Large-scale Residential Development 'Swift Square Apartments'

MH21009
F01
July 2023

APPENDIX 2.1

LRD - SECTION 247 PRE APPLICATION CONSULTATION NOTES

TIME :
3.00 PM

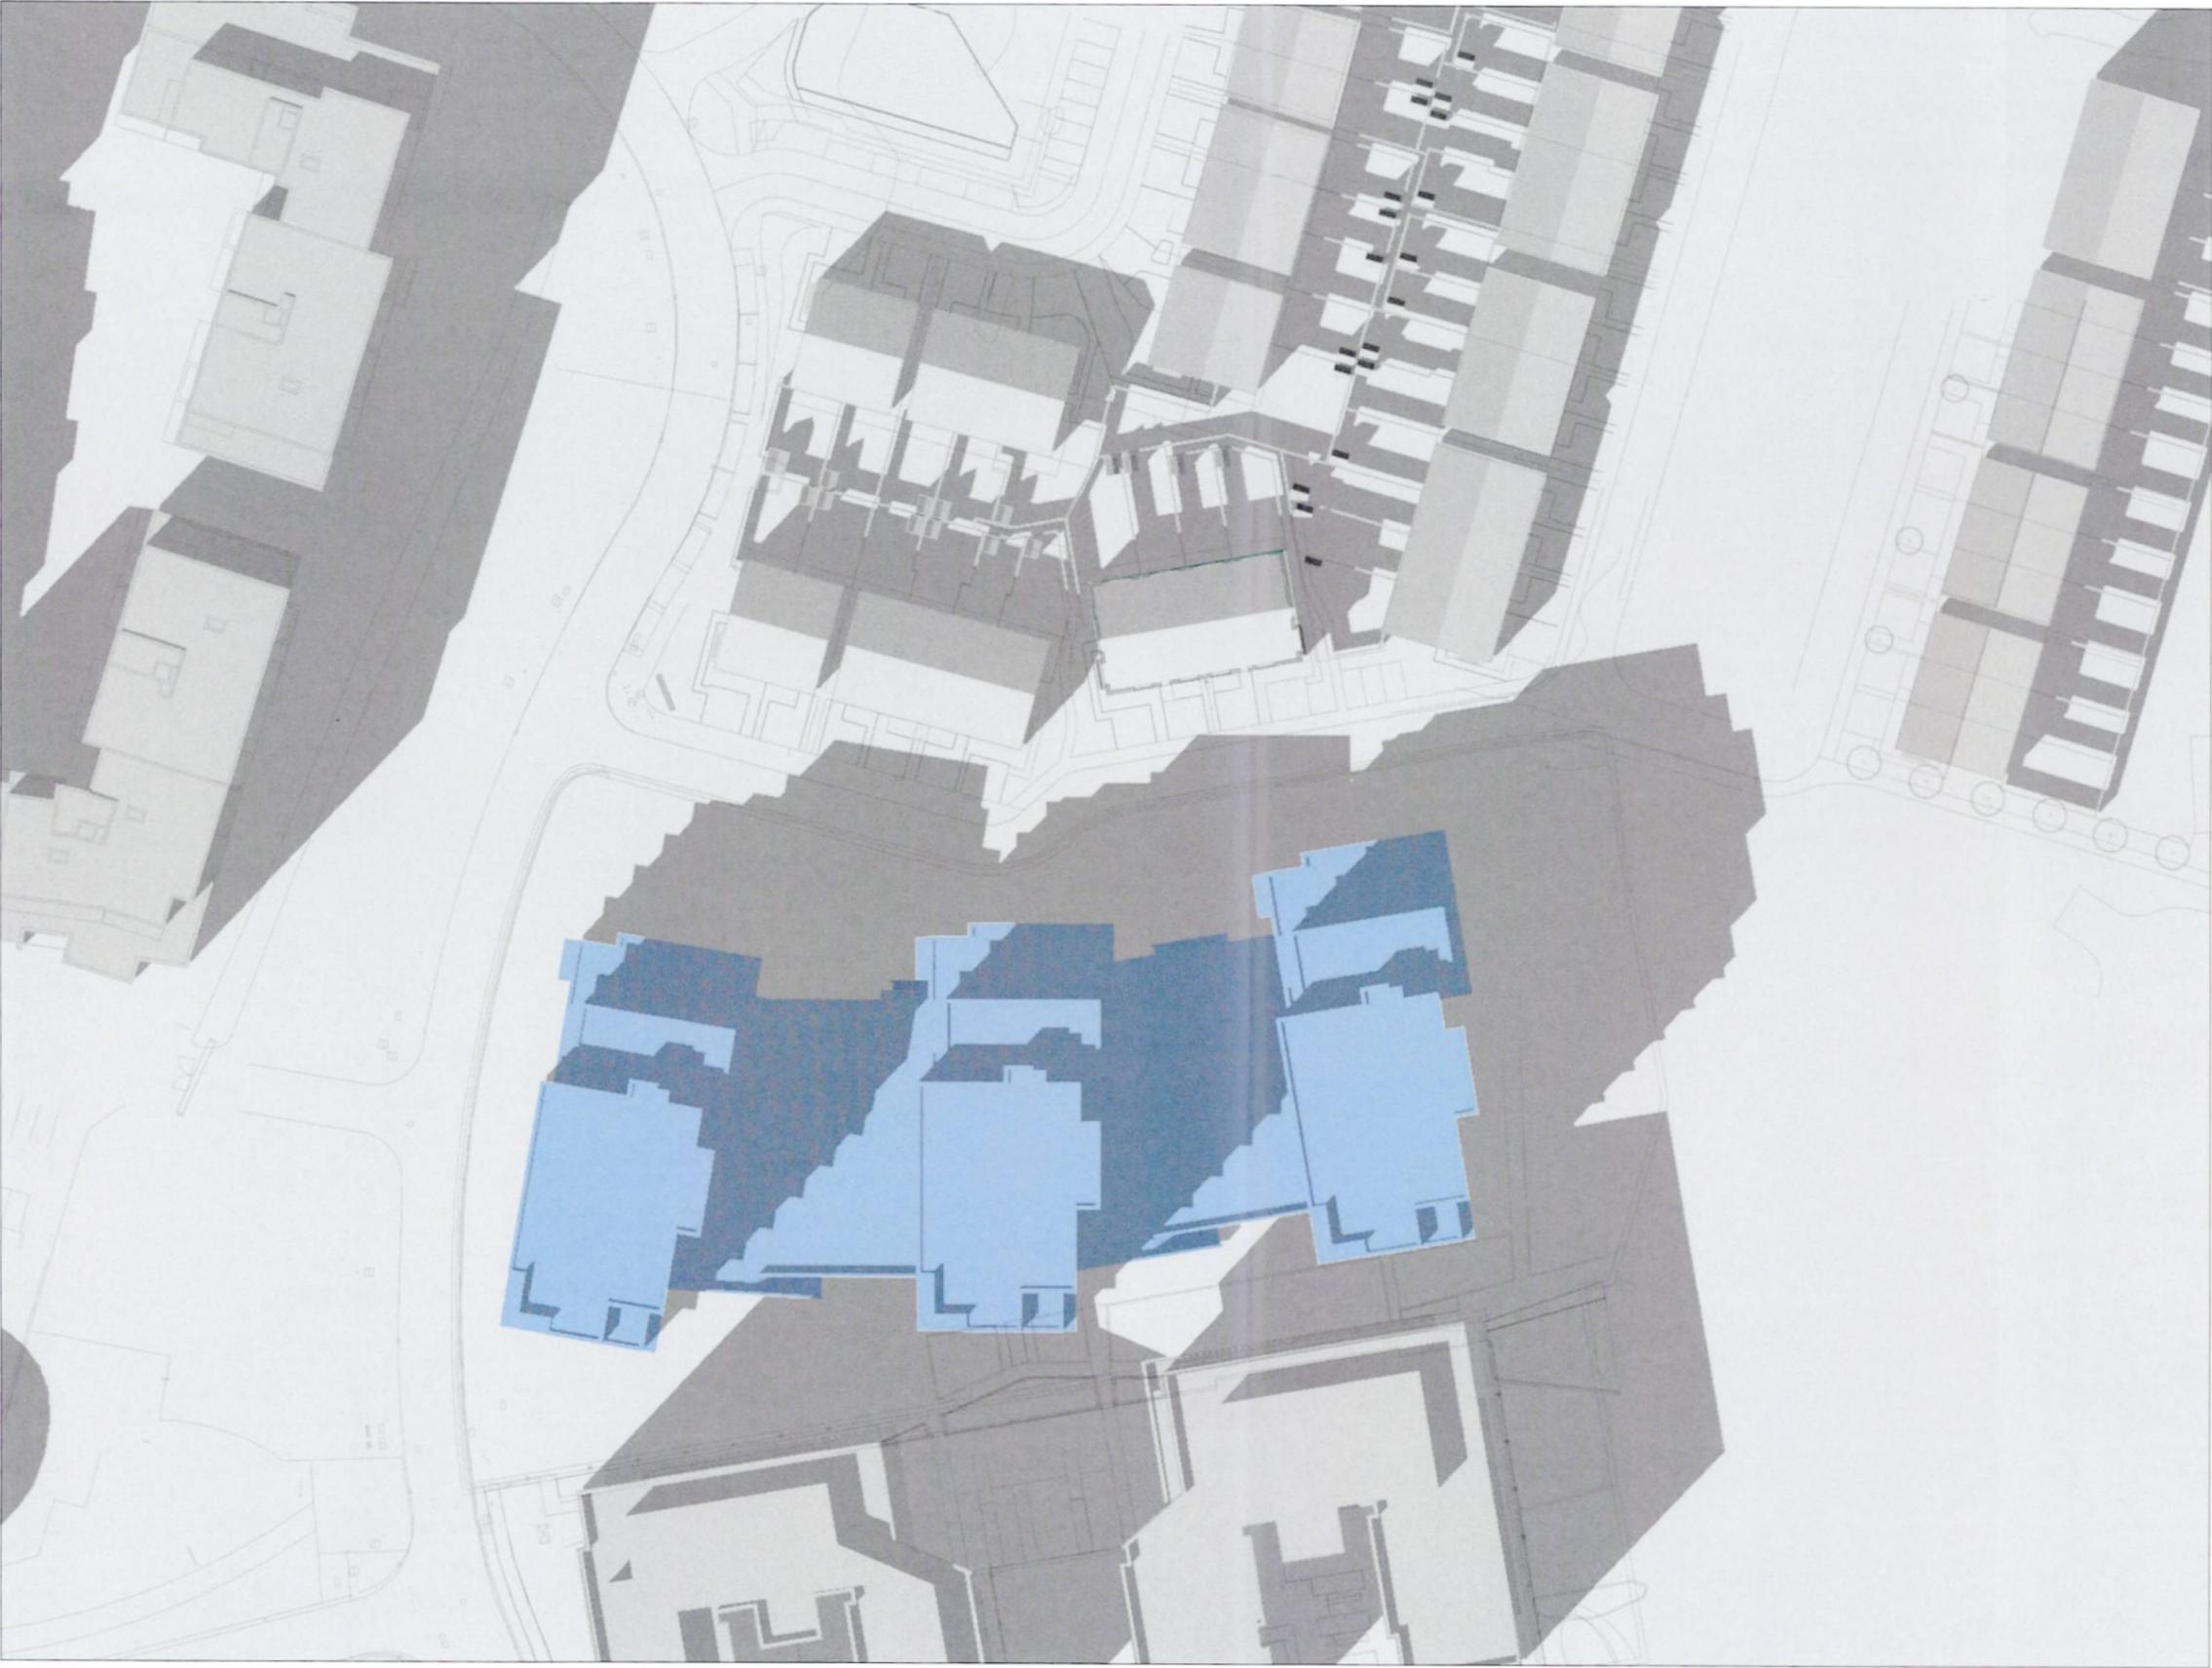
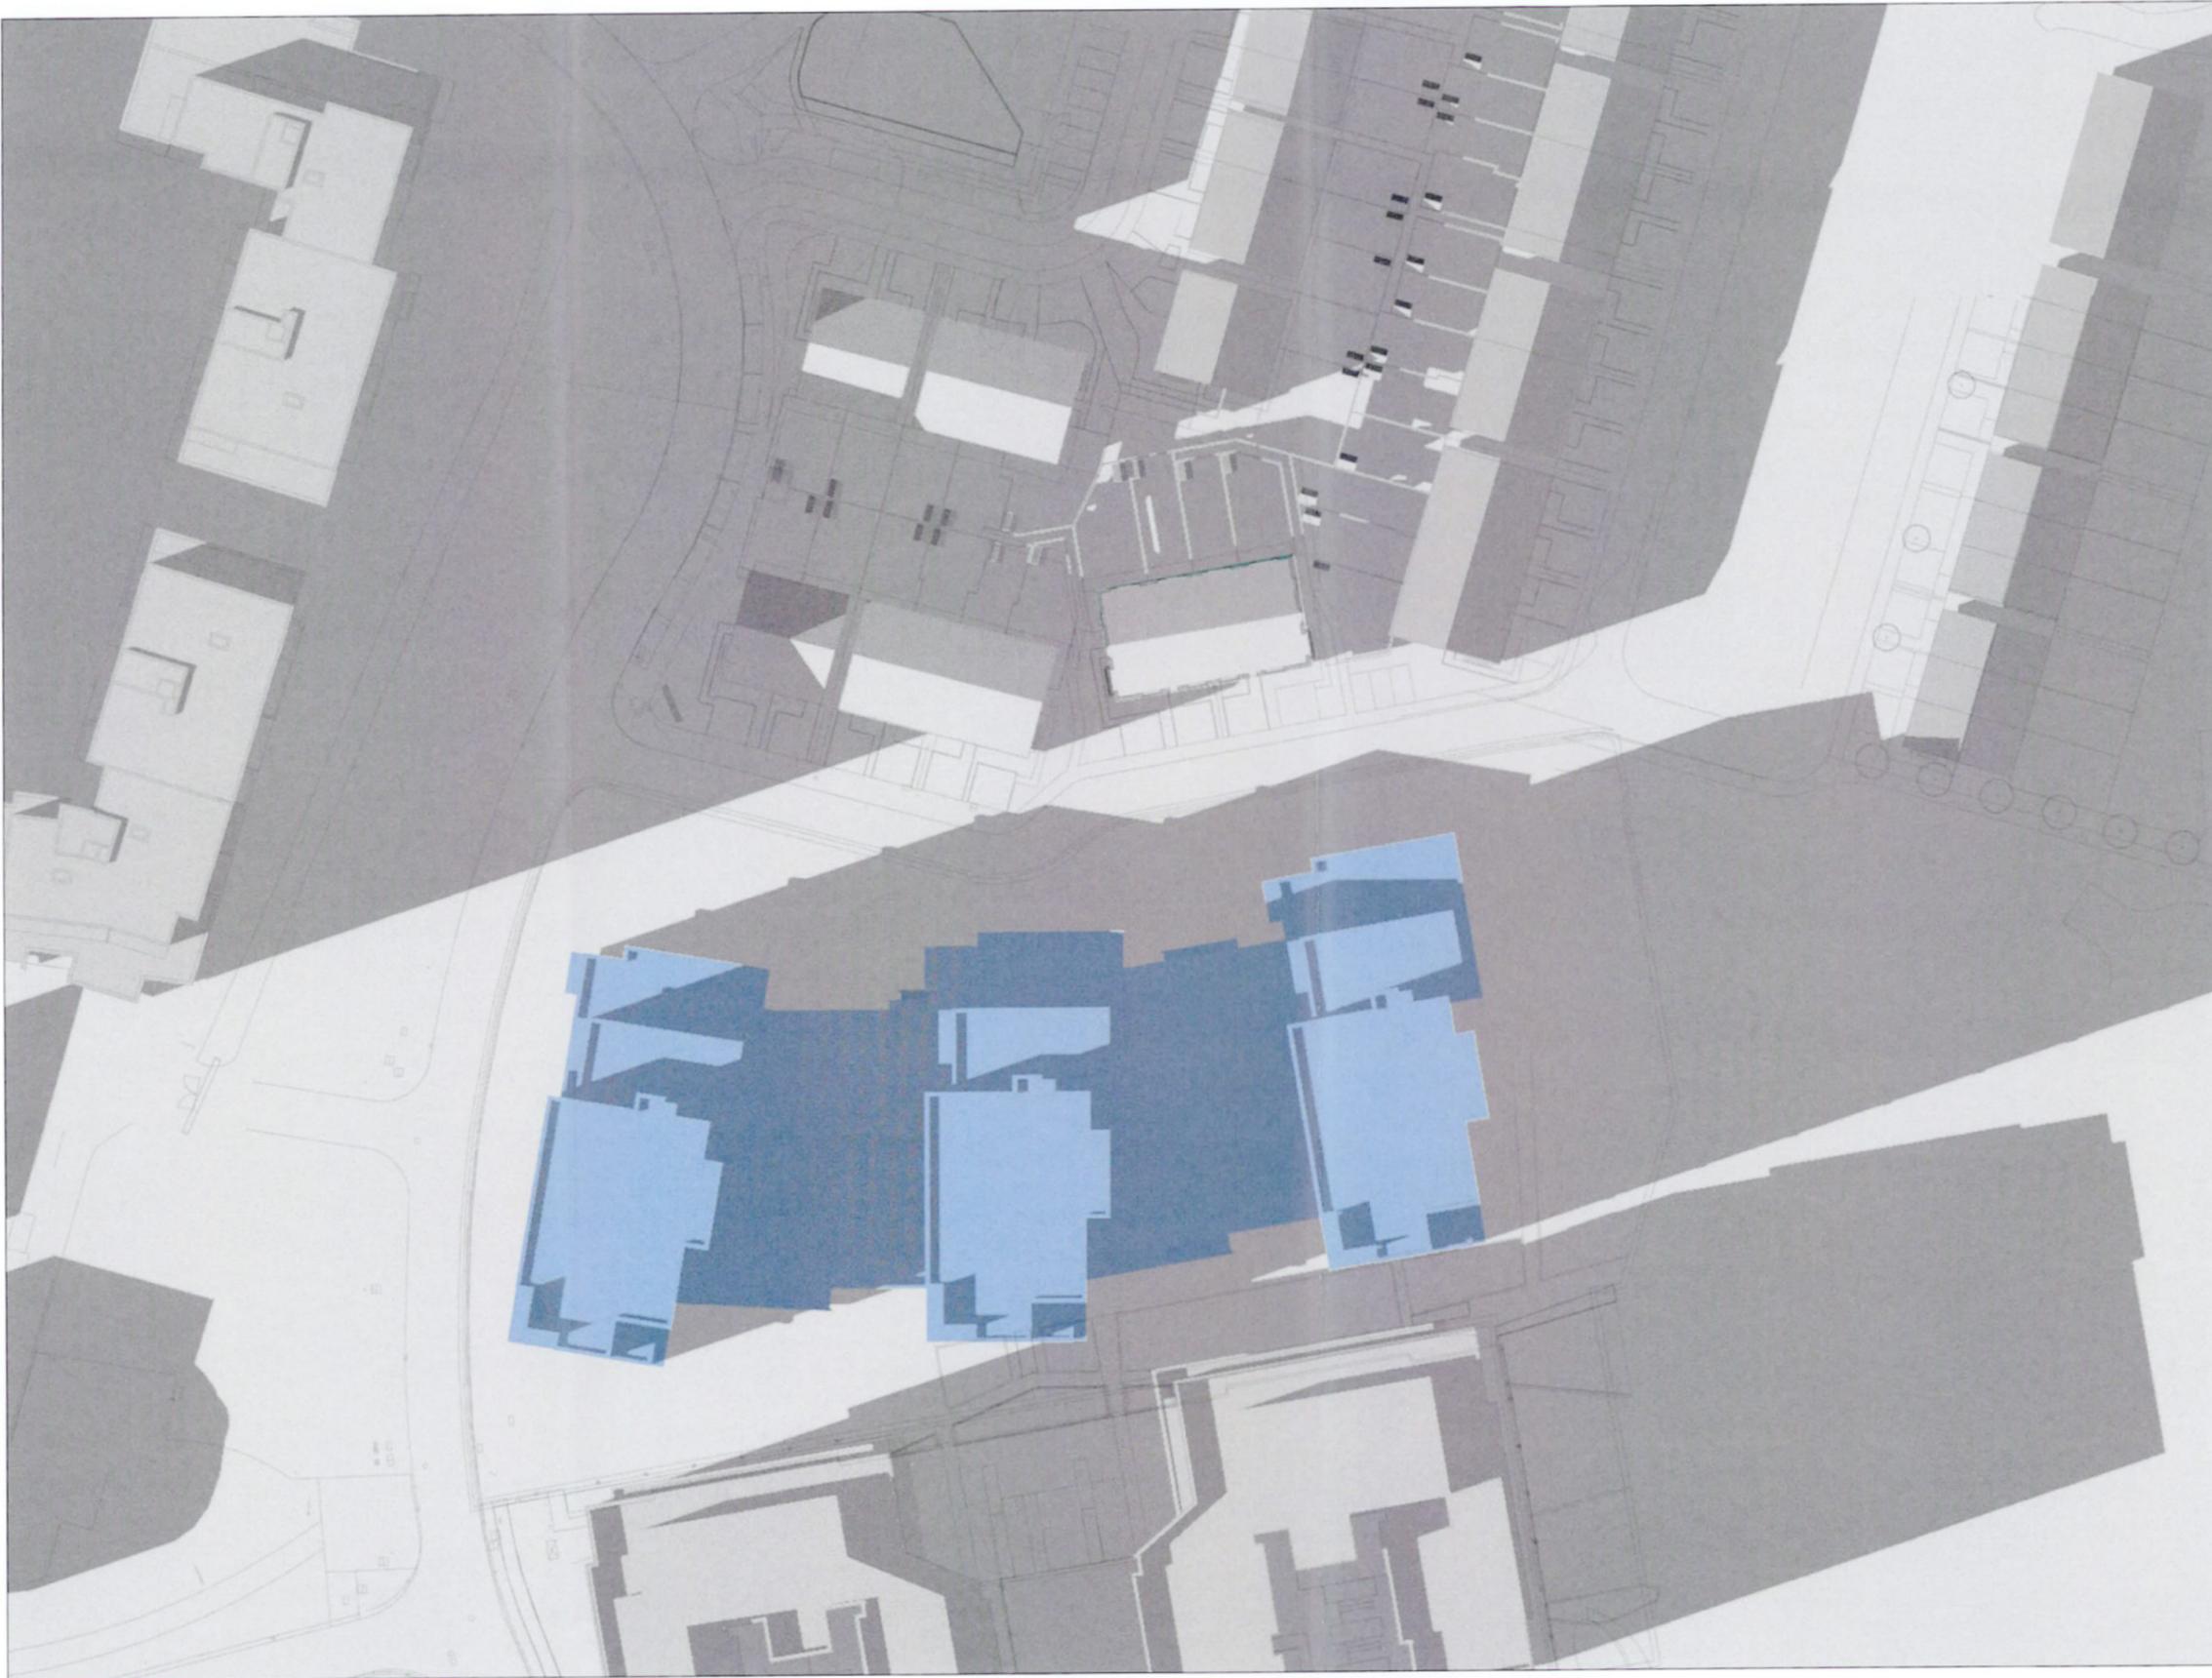
shadow analysis required –analysis to demonstrate light to gap between buildings and ADF to lower units, Overshadowing of open spaces a concern

The impacts of overshadowing on both the proposed units and the spaces are to be taken into careful consideration in the final proposal.

- Southern elevation is much improved. The pop up corners to the west welcomed.
- At the northern elevation the separation distance from Block 1 and Cedarview is 34m & the distance between Block 2 and Cedarview is 21.4m.
- Review potential to reduce the height of the block at the 21m point
- Review and refine fenestration on the northern elevation.
- Applicant should clarify the overshadowing impact on Cedarview in next proposal.
